OXFORDSHIRE COUNTY COUNCIL'S RESPONSE TO CONSULTATION ON THE FOLLOWING DEVELOPMENT PROPOSAL

Application no: 14/02156/OUT-2

Proposal: OUTLINE - 95 No new homes

Location: Land South Of Cotefield Business Park Oxford Road Bodicote

Figure 17: Illustrative masterplan

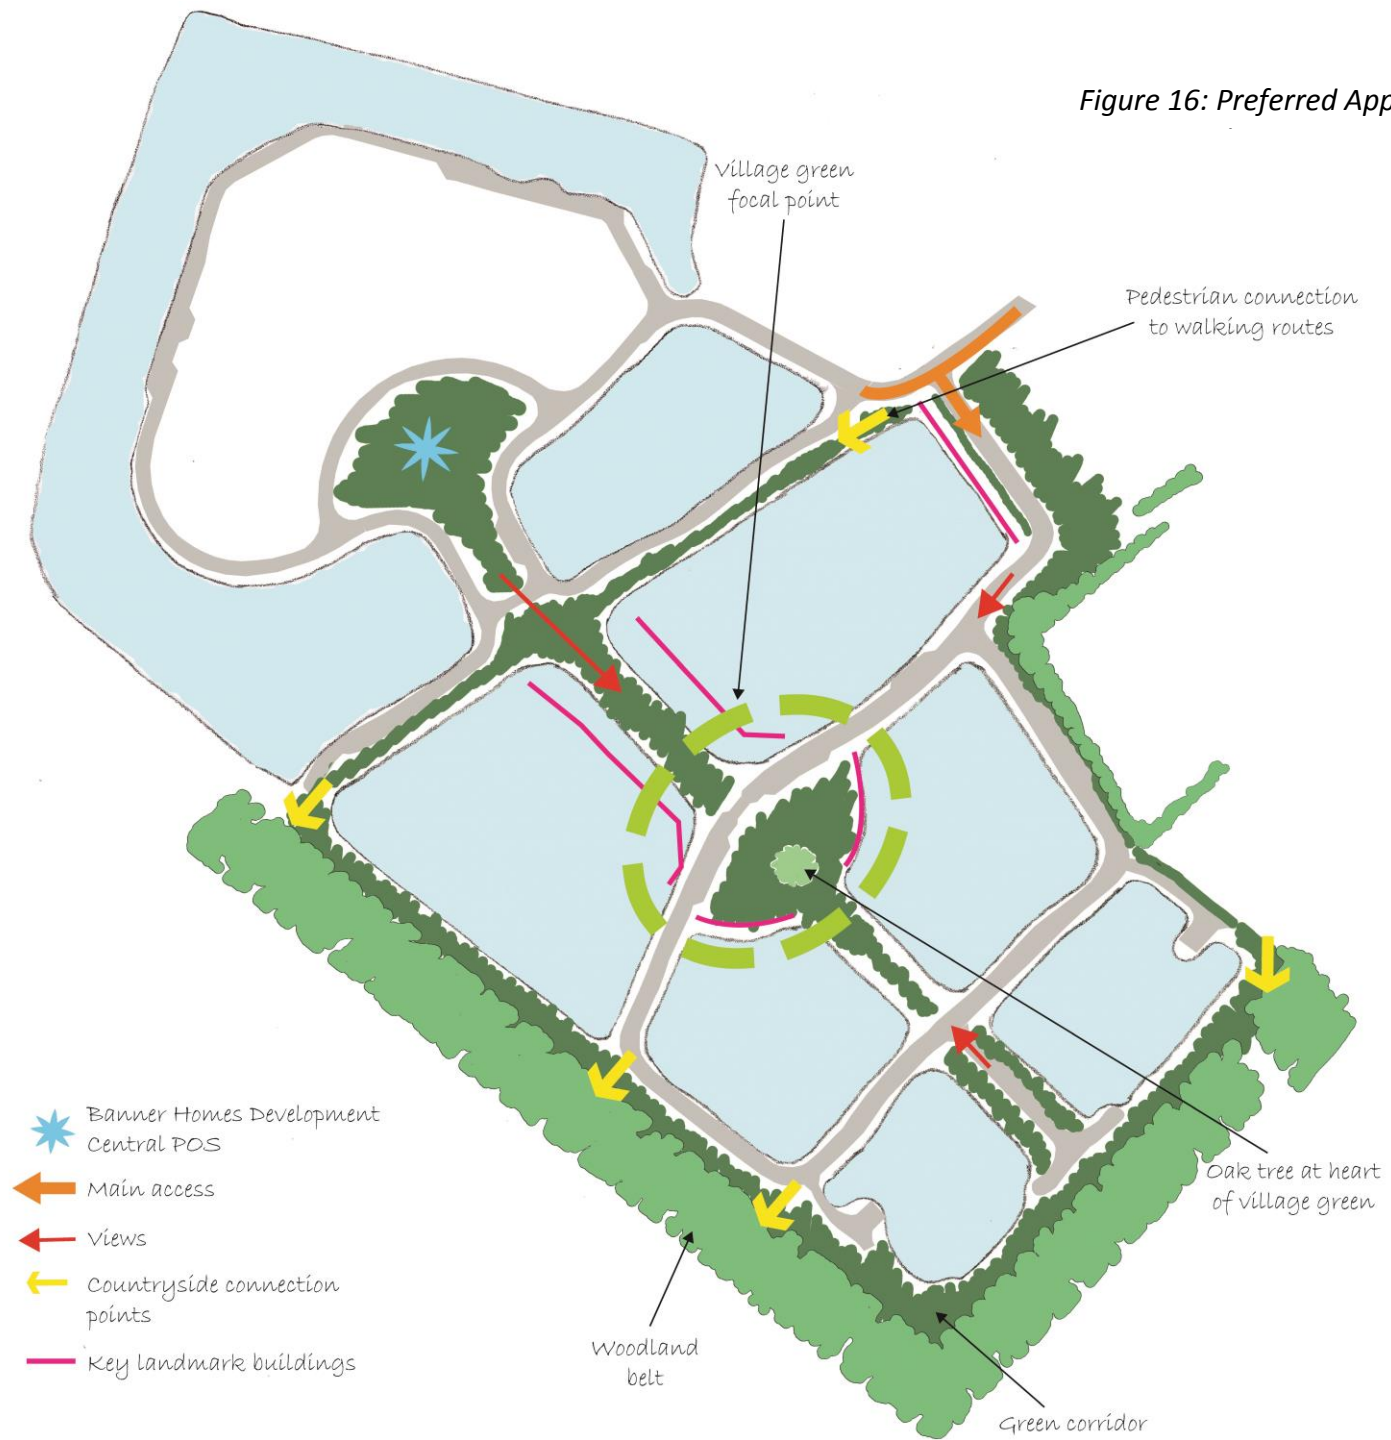
Indicative masterplan

This has not been reviewed in detail, so this should not be considered as an exhaustive list of comments:

- I am concerned that the pedestrian/cycle route through the centre of the development should be suitable for shared use in all weathers and should be as direct as possible.
- Footpath connections need to be provided into the surrounding footpath/PRoW network.
- Tracking for the full route of a large refuse vehicle will be required with a reserved matters planning application. For areas where manoeuvring into parking spaces looks tight, tracking for a large family car will also be required.
